Our Reference: SYD18/01905/02 (A27339205)
DP&E Ref: SSD 9741

LANE COVE WEST DATA CENTRE – 1 SIRIUS ROAD, LANE COVE WEST

Reference is made to the Department of Planning and Environment (DP&E) letter dated 10 April 2019, regarding the abovementioned application which was referred to Roads and Maritime Services (Roads and Maritime) for comment in accordance with the *State Environmental Planning Policy (Infrastructure) 2007*.

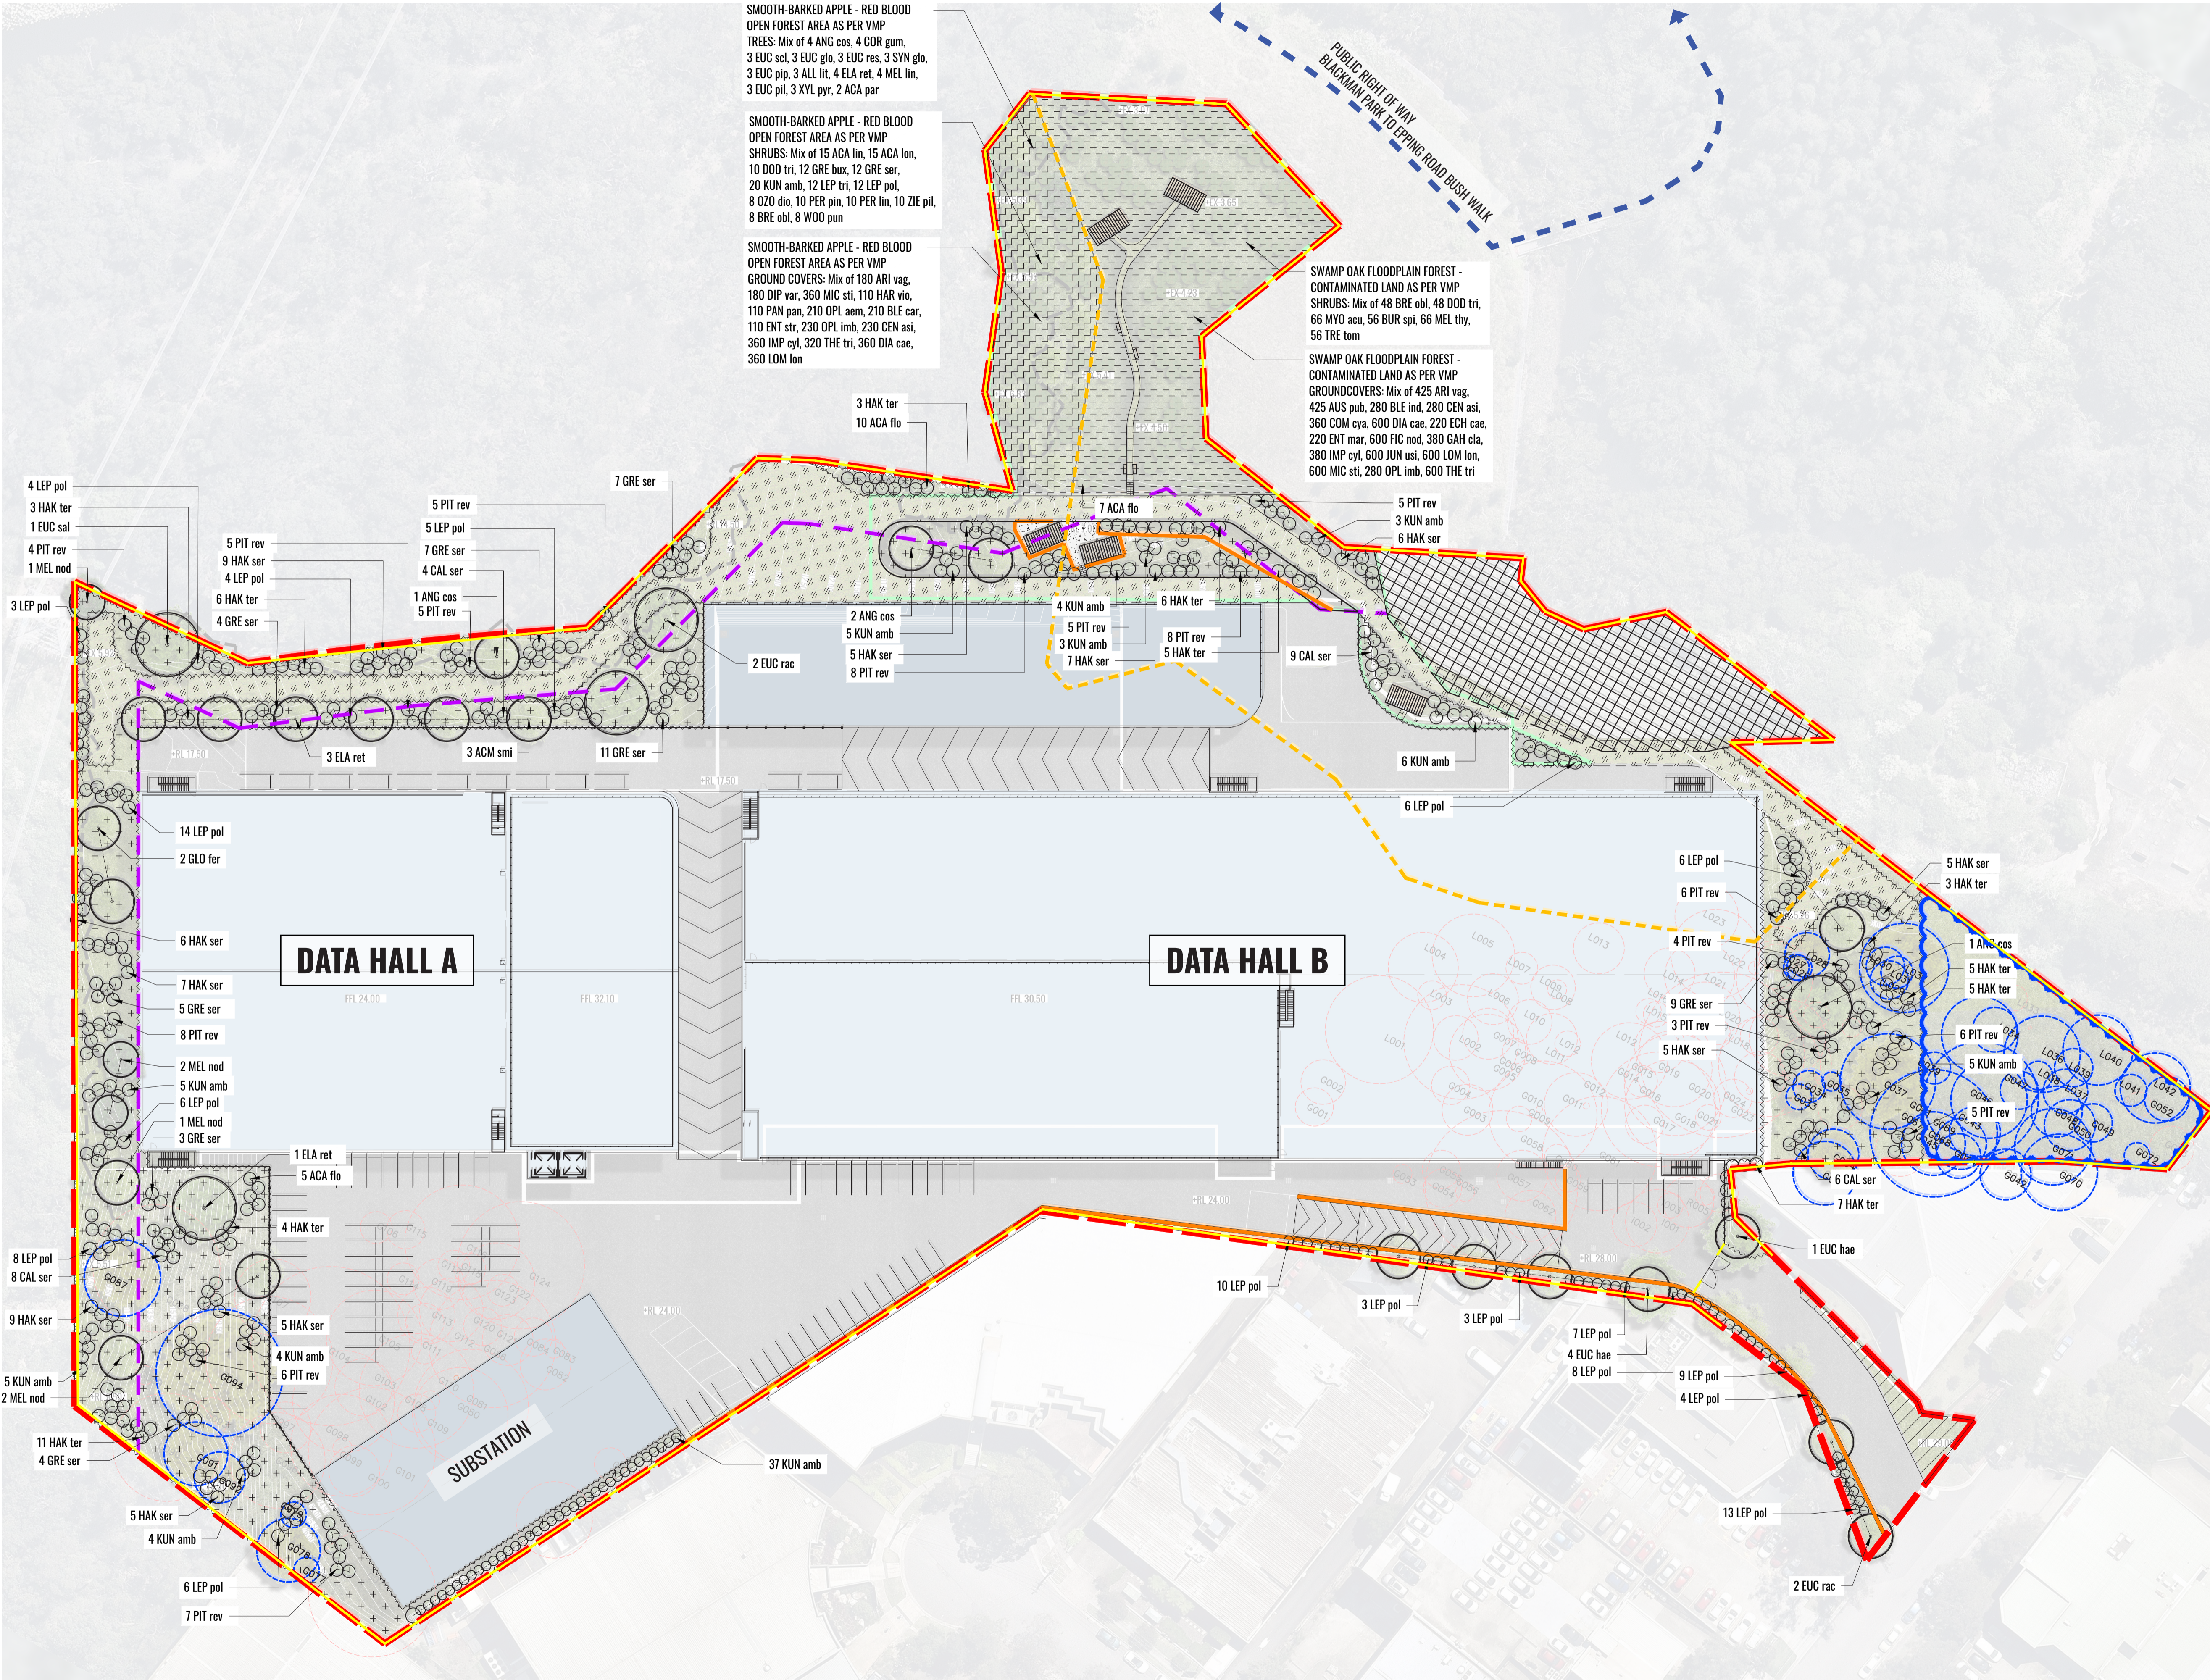
- According to the landscape plan, native canopy trees are to be planted at the south-eastern boundary of the proposed site which appears to be overhanging with 5 Sirius Road lease area. Information of the particular type of trees and vegetation should be provided for review as concerns raised regarding the tree root may damage our current retaining wall structures if they are planted too close to the retaining wall.
